WEST SUSSEX COUNTY COUNCIL CONSULTATION

TO:	Arun District Council FAO: David Easton
FROM:	Highways, WSCC
DATE:	11/9/2018
LOCATION:	Land west of Brook Lane and south of, A259, Rustington, BN16 3JL
SUBJECT:	A/83/18/RES Approval of reserved matters following outline approval A/144/17/OUT for access only for the demolition of existing buildings on site & the erection of a mixed use development comprising up to 90 No. residential units & a care home (Use Class C2 & C3) & ancillary facilities, including railway crossing, together with associated access, car parking & landscaping. This application also lies within the parishes of Littlehampton & Rustington. Amended plans received.
DATE OF SITE VISIT:	
RECOMMENDATION:	☐ Advice ☐ Objection ☐ Modification ☒ No Objection ☐ More Information ☐ Refusal
S106 CONTRIBUTION TOTAL:	N/A

Application A/83/18/RES seeks approval of the reserved matters in relation to access associated with outline application A/44/17/OUT. The applicant is proposing a left in left out vehicular access from the A259.

title
PROPOSED SITE ACCESS

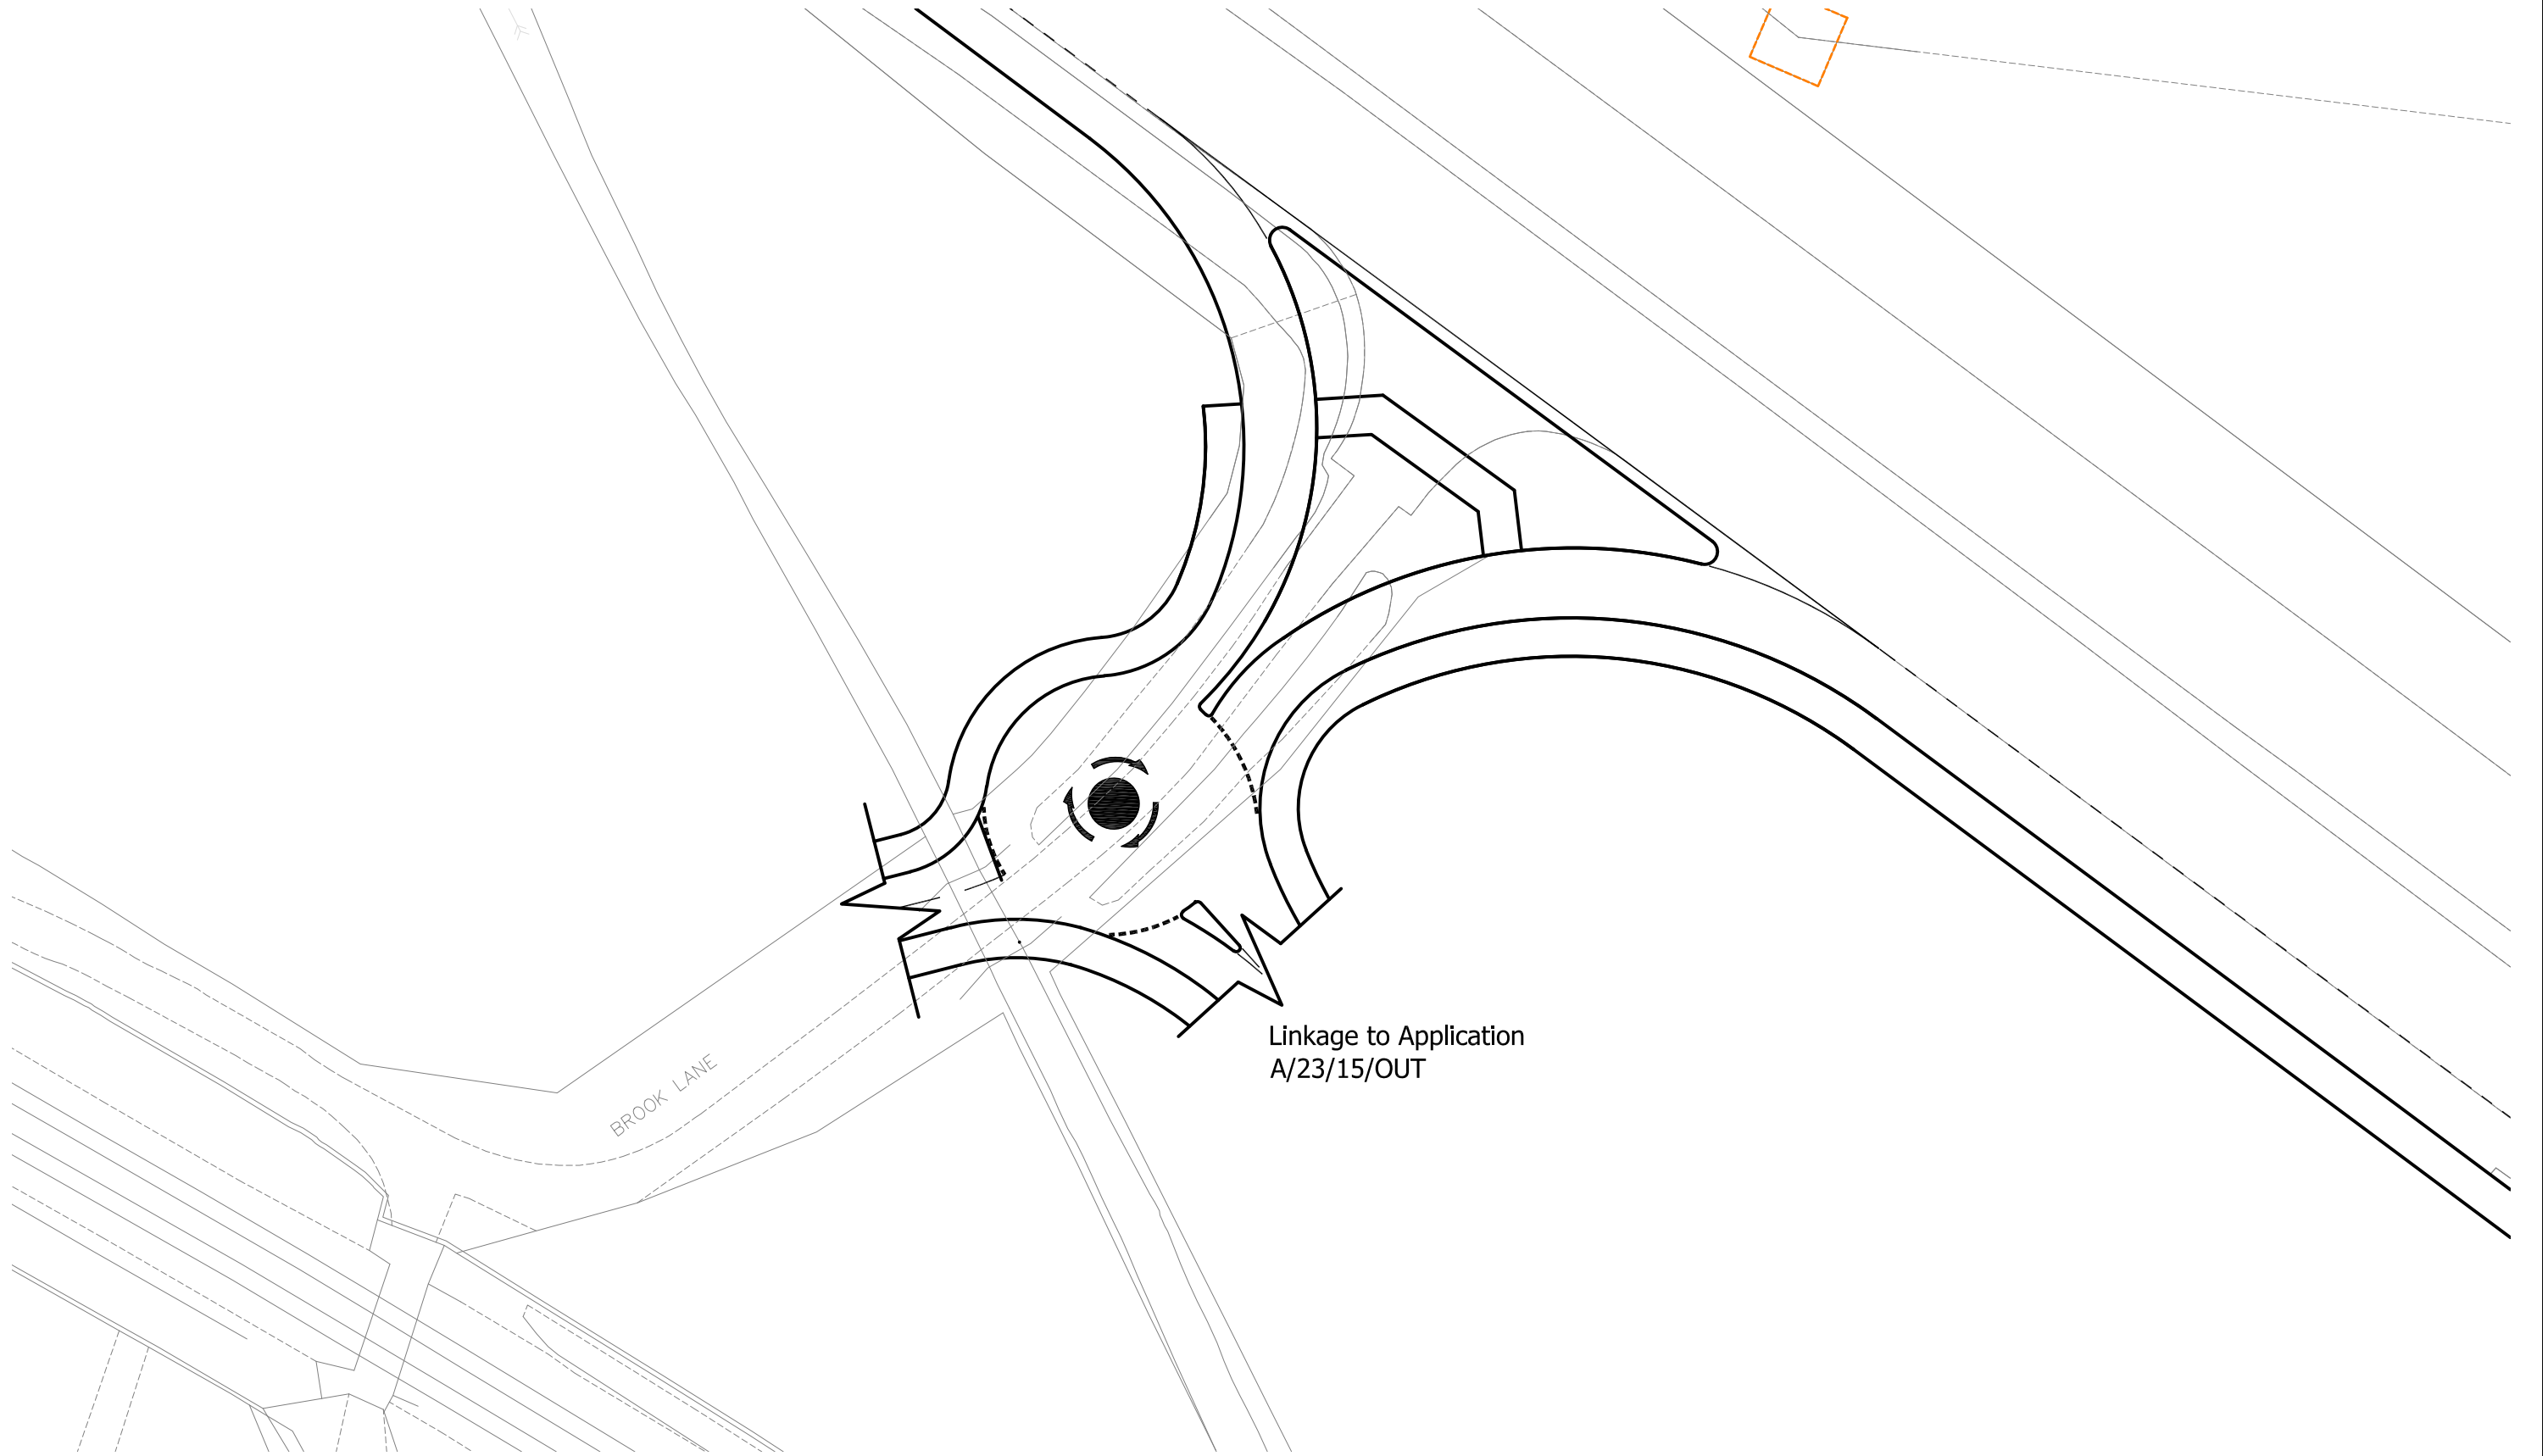
- The merge and diverge taper lanes could ideally have been increased in width alongside the traffic island so that they could be maintained without a road closure. Swept paths would inform what the actual width is within allowances for Chapter 8 signing and guarding and therefore acceptable.
- The dimensions of the acceleration/deceleration lane included within the design review are acceptable.
- It is noted that the 30m radius is less than the 40m stated as being 'preferable' in TD42/95 paragraph 7.54. This is not addressed in the design review. A departure from standards application would not be required, but it would have been beneficial for a designers comment on why it wasn't achieved or deemed necessary. The 85%ile measured wet weather speeds at diverge were previously measured at 105kph. This could have formed part of the justification for the reduced radius.
